From: Neal Chantrill <Neal.Chantrill@leics.gov.uk>
Sent: 27 June 2022 10:45
To: Thomas White <tom.white@blaby.gov.uk>
Cc: Victoria Vernon <Victoria.Vernon@leics.gov.uk>
Subject: 22/0105/VAR and 22/0506/FUL - Green Acres Aston Lane Aston Flamville Leicestershire LE10 3AA

Revision No.:	
Client:	Mr & Mrs Jelfs
Project:	Green Acres, Aston Road, Aston Fiamville, LE10 3AA
Drawing Title:	Proposed Parking and Landscaping Layout.
Drawing Number:	Jelfs-004
Remarks:	-
Date:	May 2018
Scale:	1:200@A3
Drawn By:	igb
Checked By:	igb

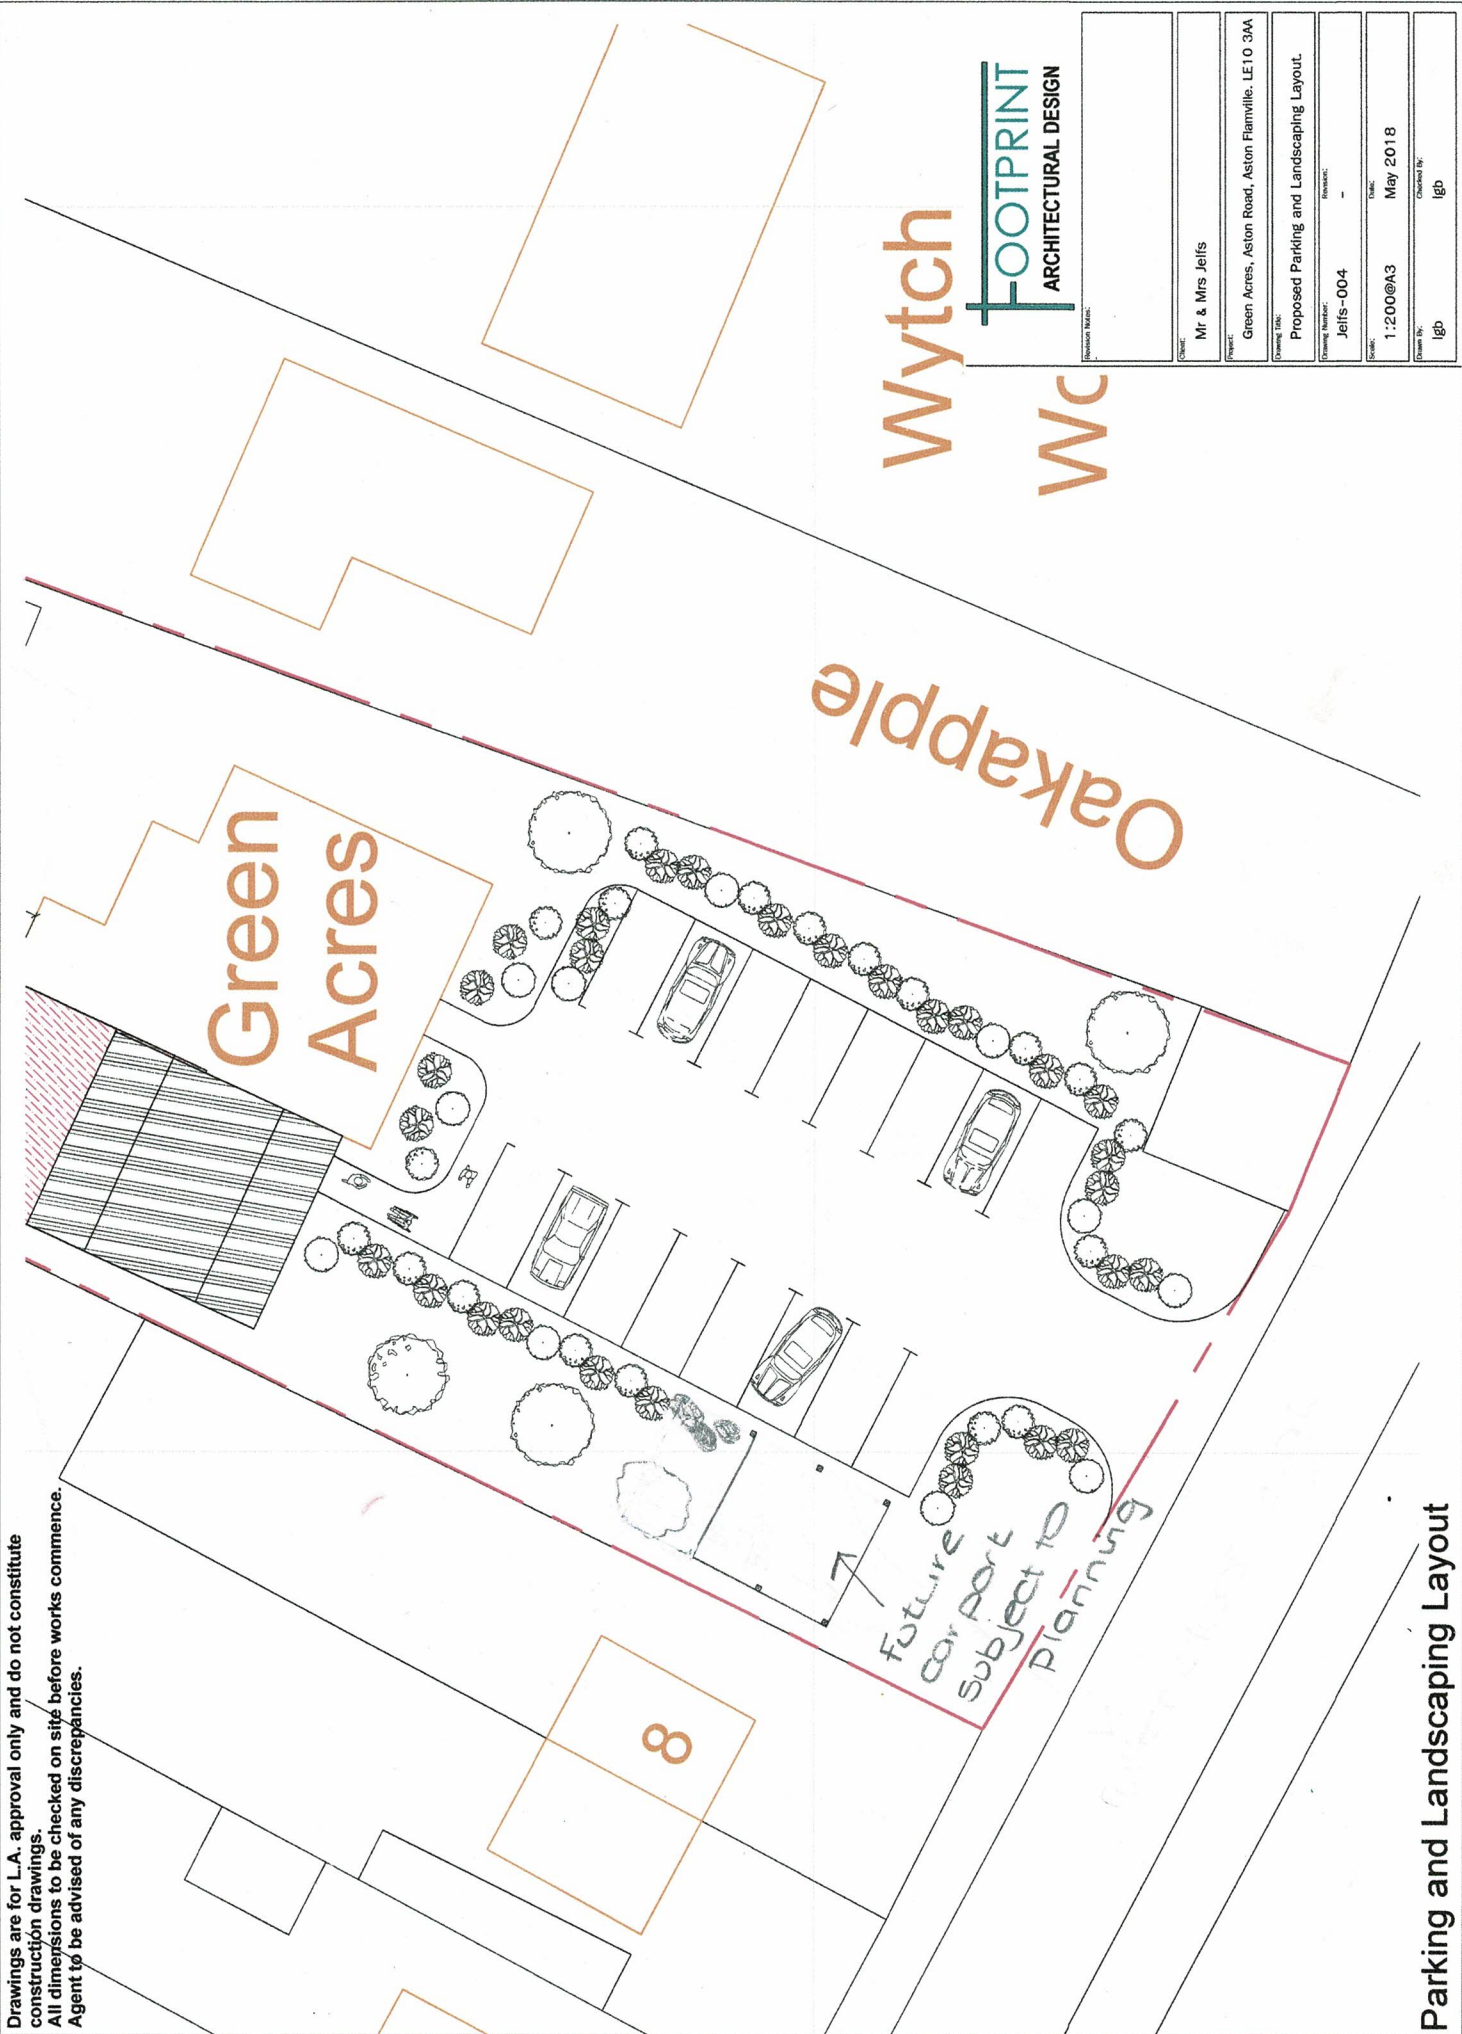
It appears that the site layout previously approved has not been implemented. It also appears that gates have been installed that open into the 2 car parking spaces adjacent to the highway. It is also noted that Google aerial view demonstrates inconsiderate car parking due to a lack of de-lineation.

As such the LHA concerned that parking has not be laid out in accordance with the plan. Given the existing gates would impede the use of at least 2 of the approved spaces and the LHA would want to seek clarification over whether the applicant intends to implement this access or whether the LHA are assessing the application based on the access which has been built? In which case the LHA would need to fully assess the appropriateness of the existing access.

Given the above, and without the proposed increase being supported by a parking accumulation study to evidence sufficient parking is available despite there being a loss against the approved drawings, I'd be cautious over any increase which could lead to overspill onto the existing highway in this location.

It is also noted that within the documentation for both 22/0105/VAR and 22/0506/FUL, the car park has been described as have 16, 17 and 18 existing spaces, the Applicant should clarify situation.

In terms of 22/0506/FUL, given this is a business tandem car parking is not encouraged, the gates for the cycle parking would also open into the one of the car parking spaces.
